Attachment A – Detailed Response to Submissions Table

Attachment A – The Sutherland Hospital Operating Theatre Upgrade (SSD-11099584) – Detailed Response to Submissions Table

CLIENT	HDR
PROJECT	Sutherland Hospital Operating Theatres

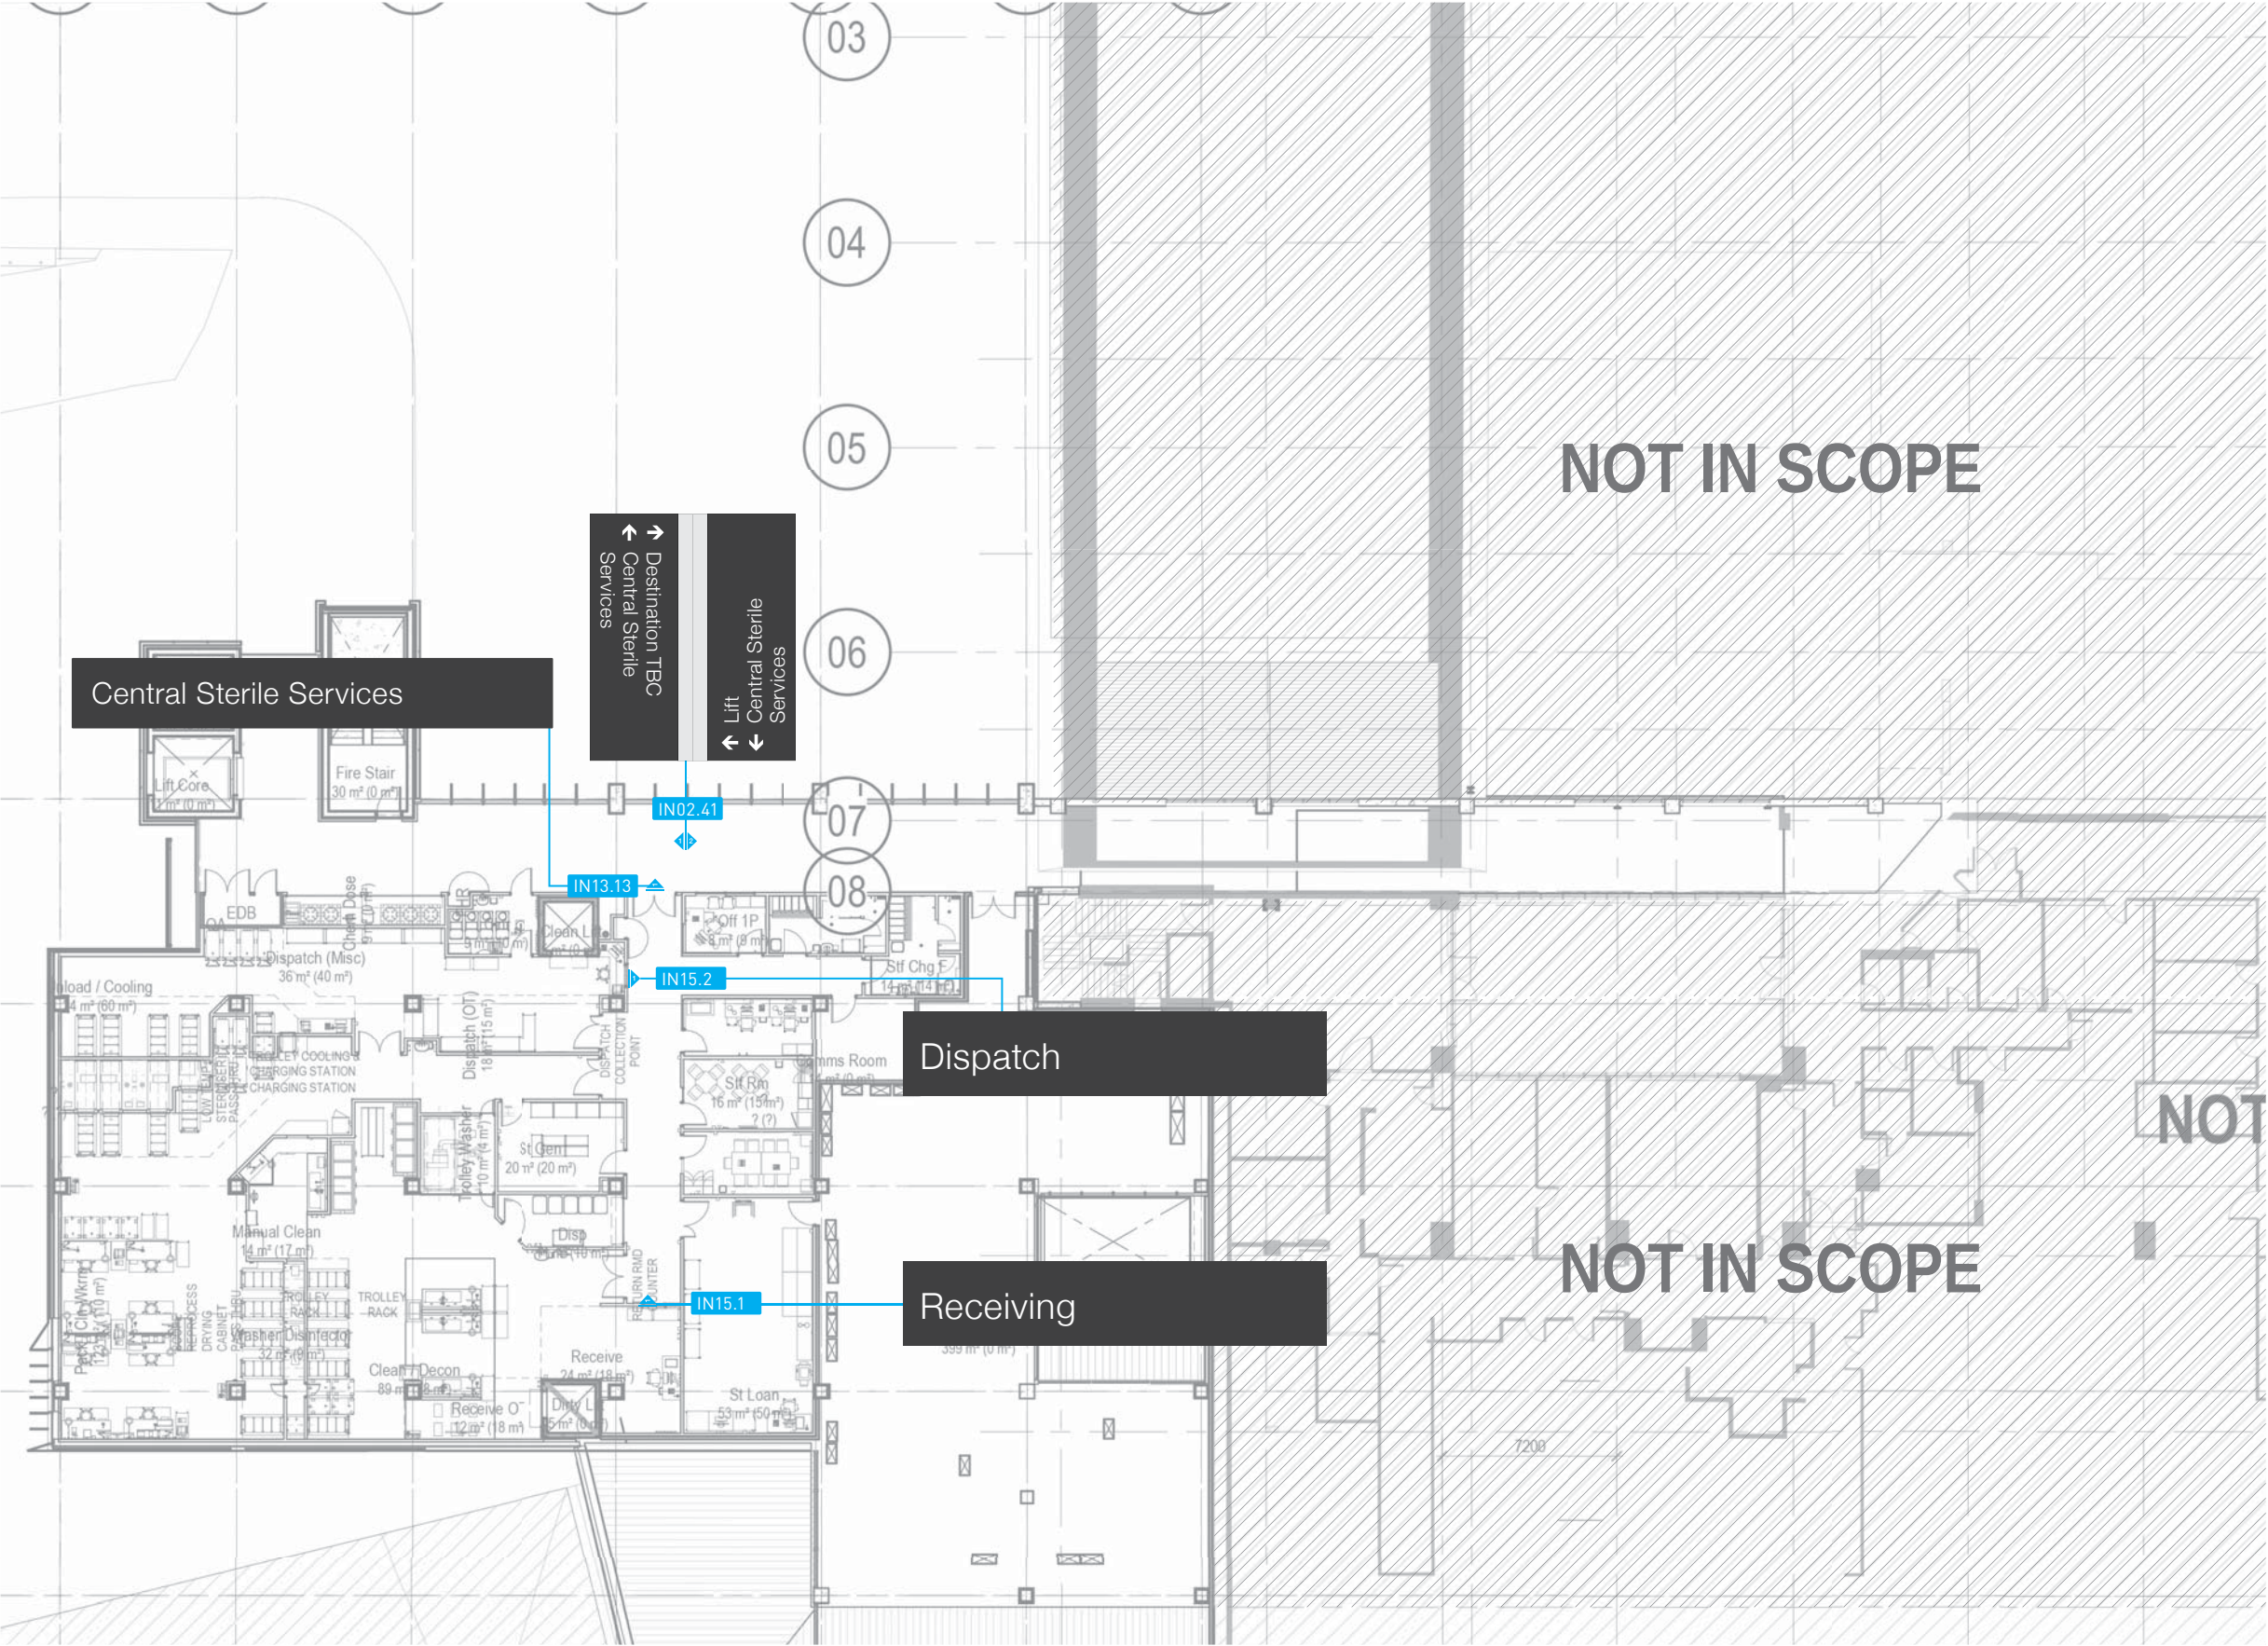
Issue raised in agency submission	Proponent's response
Department of Planning Industry and Environment (DPIE)	
<p>1 Access</p> <p><i>While the main hospital entrance is not being altered or changed in the proposal, the proposal also includes a smaller entrance, which may cause confusion when patients are entering the site. No signage has been included in this proposal but should be incorporated to improve wayfinding across the site.</i></p>	<p>A wayfinding strategy has been developed for the proposed development by Brandculture and is provided at Attachment C and Figure 1 below.</p> <p>The wayfinding strategy provides further information on the legibility of the entrance to the building including the signage to be used at the entrance fronting the car park. As depicted below the signage on this frontage is quite minimal so as to not appear as a key entrance to the public. Note also that the signage notes that Level 1 is for staff only.</p>  <p>Figure 1 Proposed wayfinding signage at the entrance to the operating theatre building. Source: Brandculture</p>

LANDSCAPE PLANTING AND SHADE CONSIDERATIONS

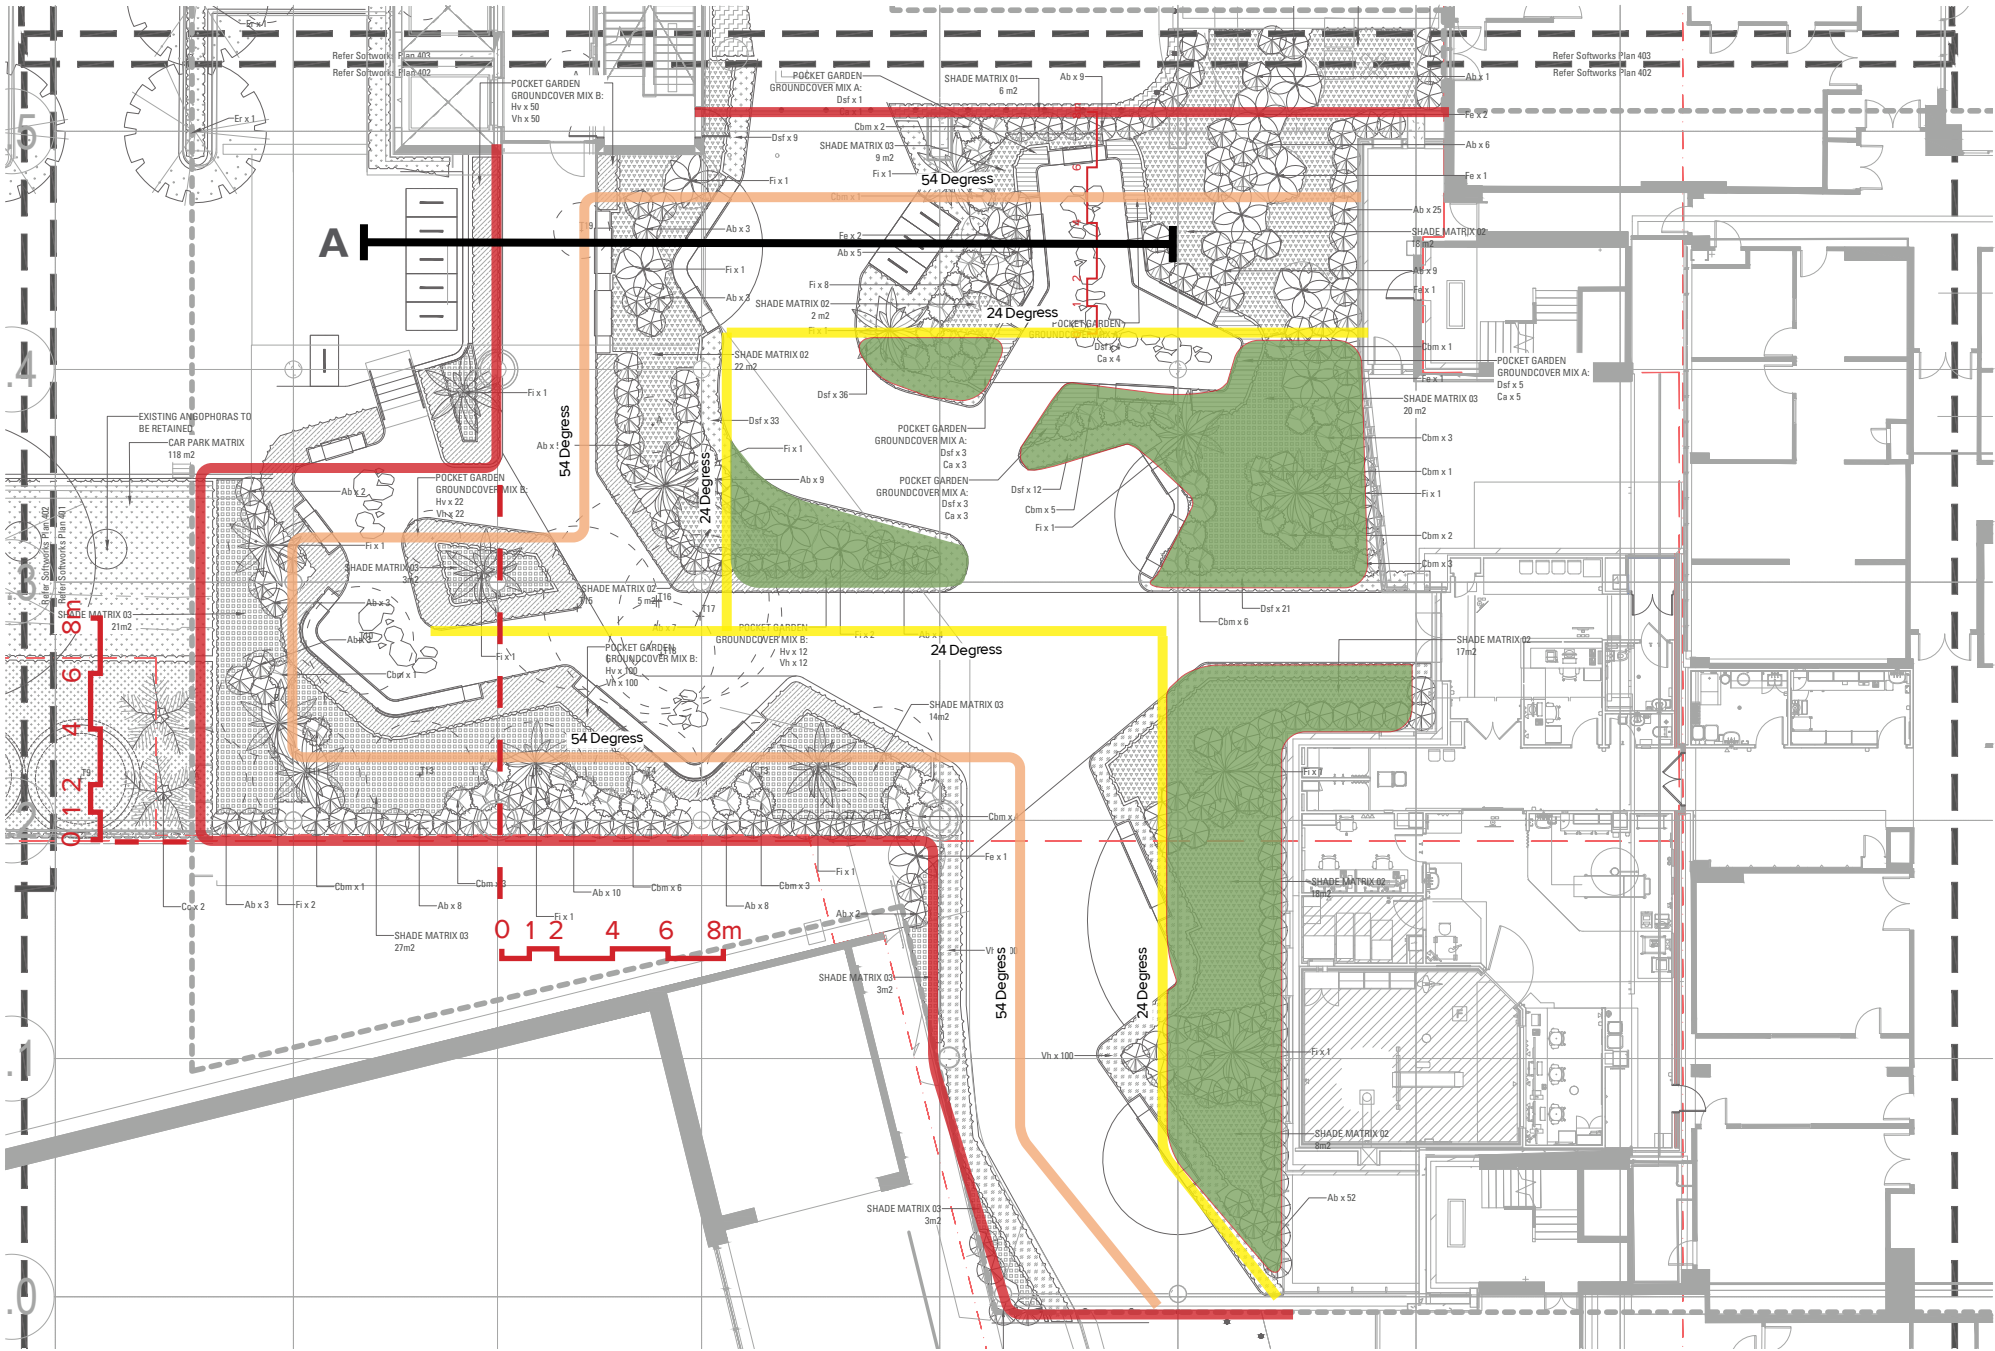
Issue raised in agency submission	Proponent's response
<p>13 <i>Plant species below the cantilever will need to be shade and wind tolerant as this area will become a wind tunnel. Irrigation will be essential due to its enclosed nature.</i></p>	<p>- Locating a landscape area on the roof precludes any future expansion of the building on an already constrained site.</p> <p>As per the response above, there is adequate sunlight to the cantilever to support the species proposed for this area. Further, the existing NSW Ambulance station creates a wind buffer for the site from south to west which shields the undercroft area. Additionally, tree planting within the car park will provide a wind buffer from the wind from the west of the site. The landscaping of the undercroft has been chosen based on how much sunlight the various areas of the undercroft will receive. Figure 8 below is an excerpt of Attachment E and demonstrates the landscaped area receives variable levels of sunlight during summer and winter months. The landscaped area shown in green is identified as receiving minimal direct light and as a result hardy species have been chosen in this location.</p>  <p>Figure 8 – Landscaping plan demonstrating varying sun exposure. Source: Arcadia</p> <p>In summary, the landscape proposal includes a variety of plant species that are robust and can survive in low light conditions (where appropriate) and can withstand prevailing wind. Proposed plant species are referred to in Landscape Drawing ALA-LA-DG-400 and is attached at Attachment F.</p>

Issue raised in agency submission	Proponent's response
	<p>Undercroft – Solar access</p> <p>The undercroft area will receive sun in both summer and winter months. Sun access in summer months is modelled with an angle of 54 degrees and winter sun access is modelled with an angle of 24 degrees. This is to reflect the sun path being higher in the summer compared to winter. A greater amount of sunlight is achieved in winter when the sun is lower in the sky, however the solar access in the summer months is also of a reasonable level, as demonstrated below.</p>  <p>Figure 7 Plan excerpt showing sun access to the undercroft. Source: Arcadia</p>
Sutherland Shire Council	
<p>Following review of the plans and accompanying documentation, the following concerns are noted for your consideration in the assessment of the proposal.</p>	<p>Refer to responses to each item below.</p>
<p>8 Building entrance</p> <p>The external expression and chosen materials for the proposed addition relate comfortably with the existing buildings. The only aspect which may confuse the public is the prominence placed on the new entry along the northern elevation as it seems to be more for staff access. As the public's main entry will remain unchanged, this new entry may confuse the public.</p>	<p>For the reasons noted above, the northern elevation does not read as a main or public entrance to the building.</p>
